Local Policing Support Team

Your Ref: AL/33/19/RES

Date 17th May 2019

RE: Barnside, Hook Lane, Aldingbourne. PO20 3TE

DWG | Proposed Site Plan

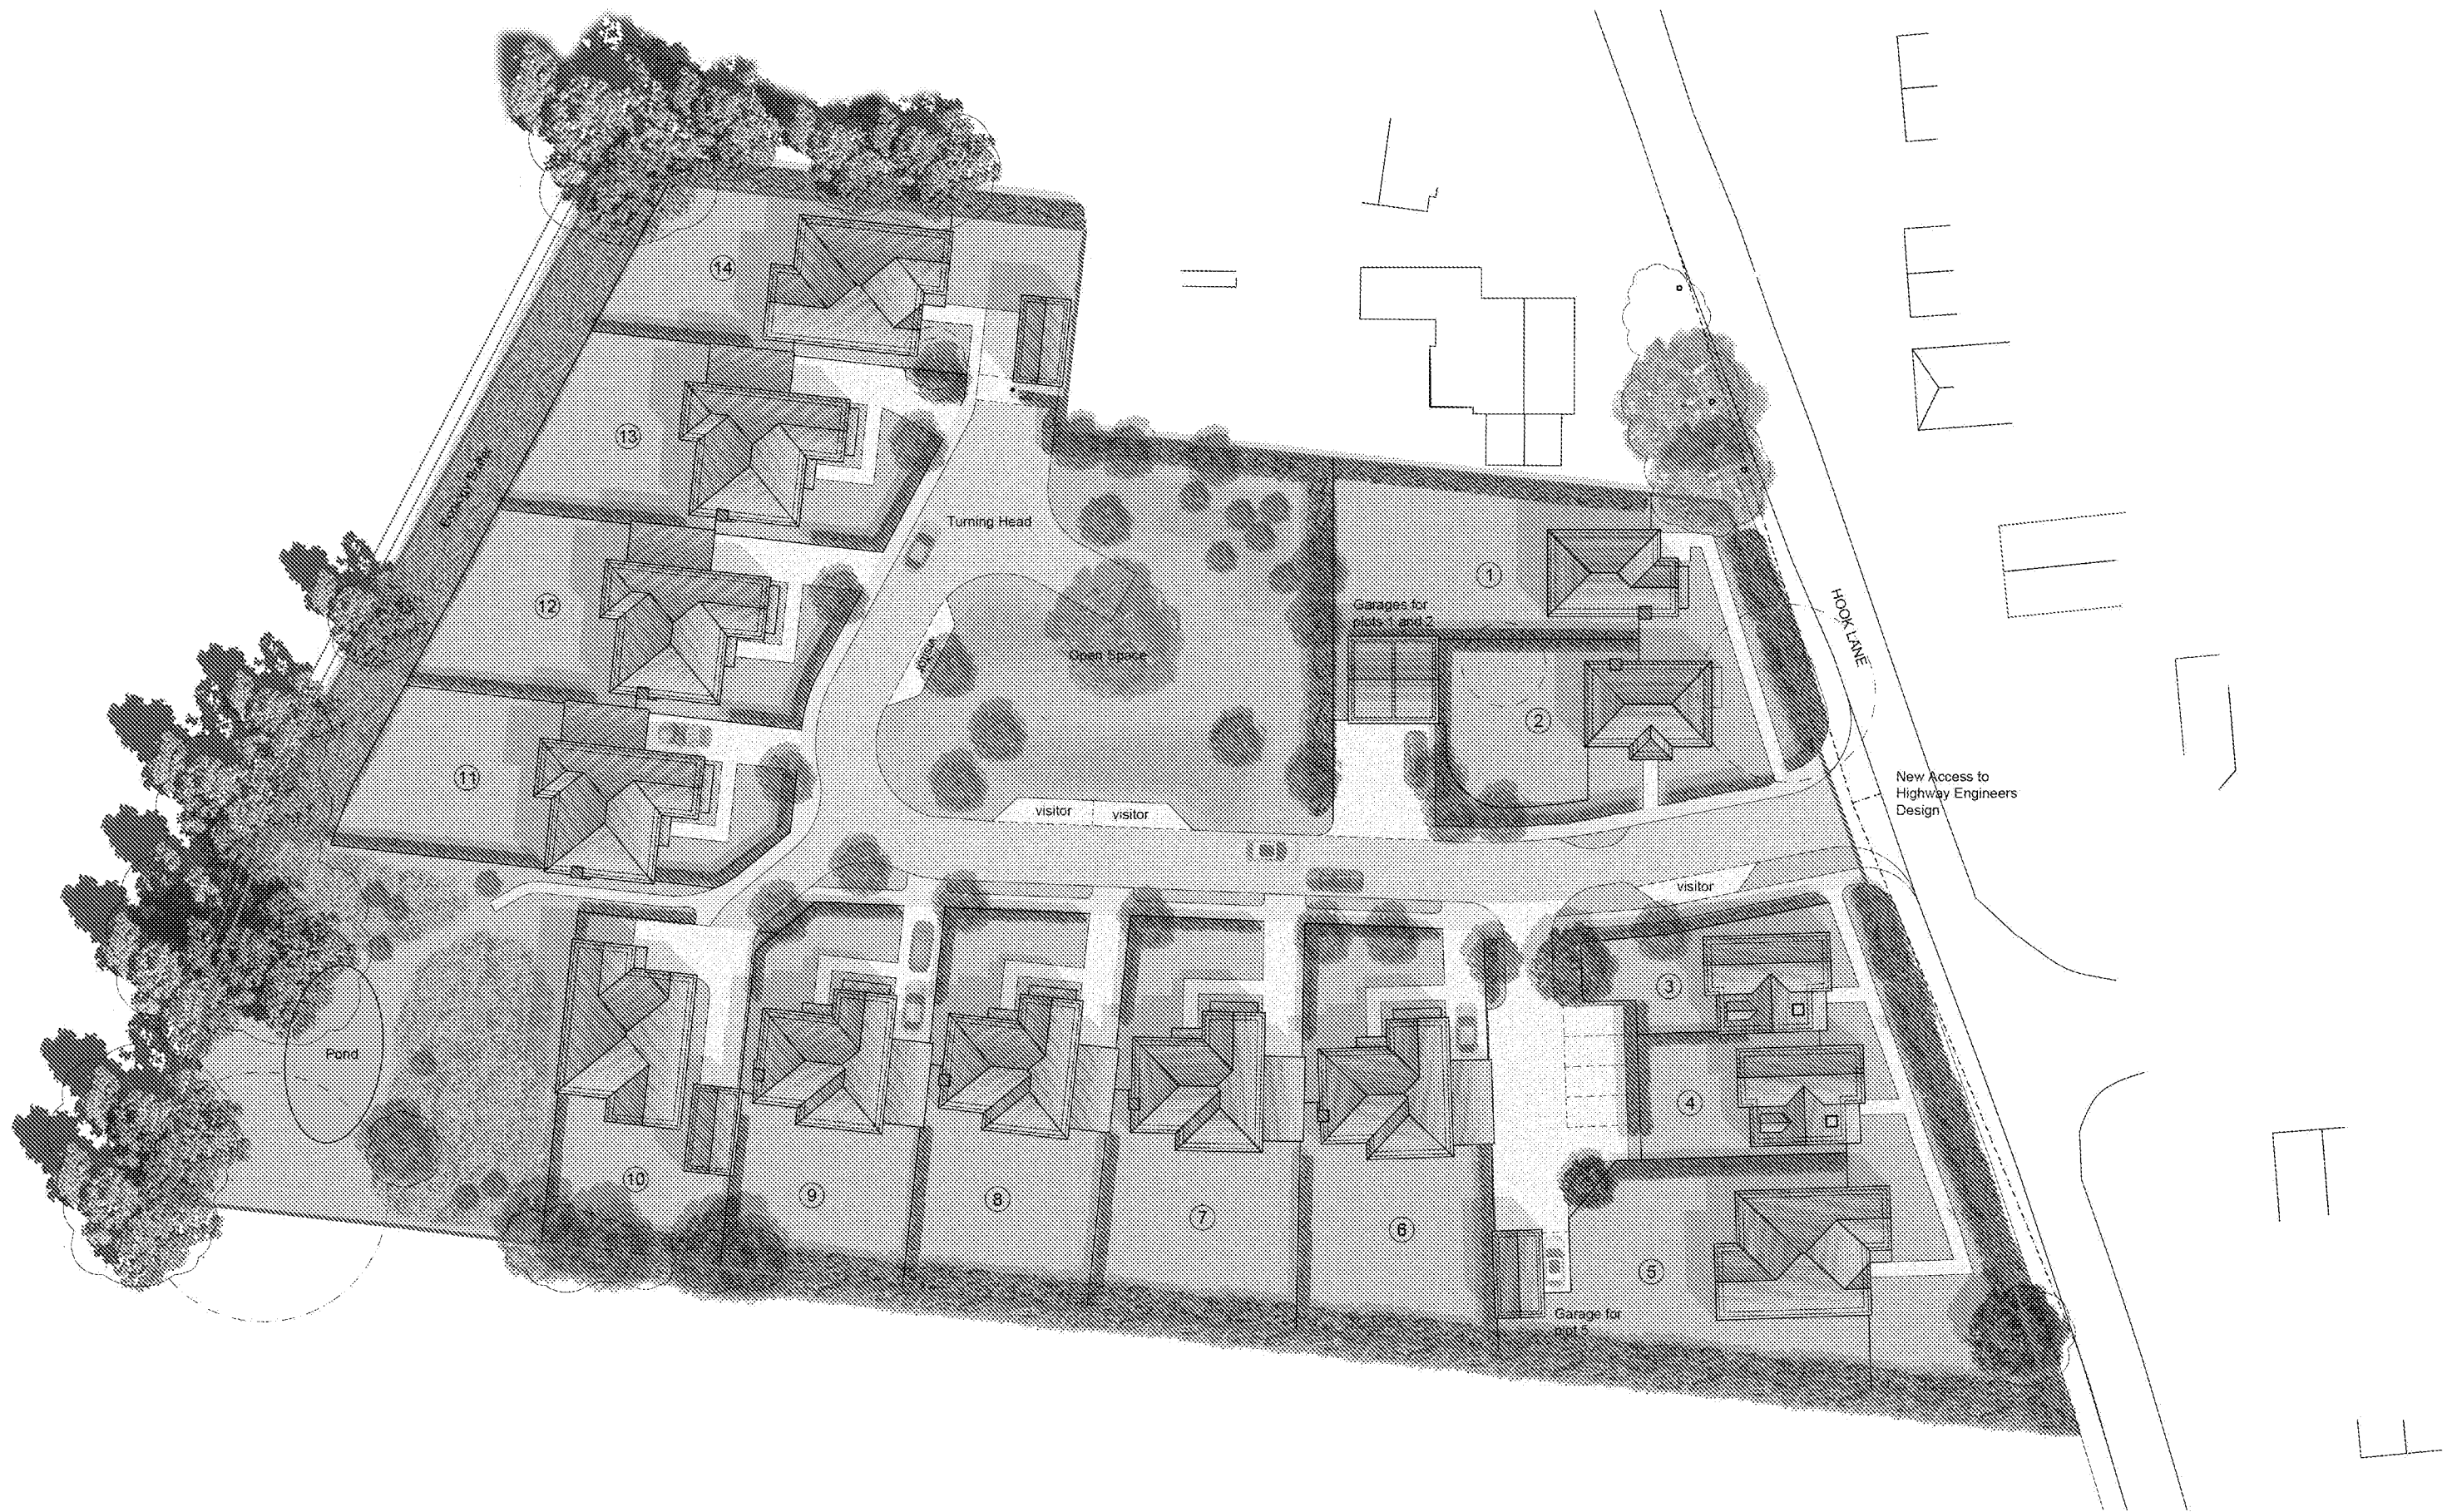
I draw the applicant's attention to the parking area within the first part of the access road of the development and located on its southern side of the road behind plots 3 and 4.

The rear access to those plots is most likely to be used to access the occupant's vehicles. The rear fence and gate provides the first layer of defence to protecting the back garden and back doors and windows from unlawful access. When leaving the back garden, unless there is a means for residents to lock the gate behind them, it leaves the gate insecure and the house more vulnerable to unauthorised access.

Gates that provide access to the side of the dwelling or rear access to the gardens must be robustly constructed of timber, be the same height as the adjoining fence and be lockable from both sides.

Plots 3 and 4 have no garages. I recommend that they have a secure shed in which to store bicycles paragraph 56.2 of SBD Homes 2019 provides recommendations for secure bike storage.

If the pond area is used for public open space, I would recommend there must be surveillance of the area from nearby plots 10 and 11. To ensure that the area can be viewed, any bushes and planting should be kept trimmed. (See Paragraphs 9.3 to 9.3.4 of SBD Homes 2017).
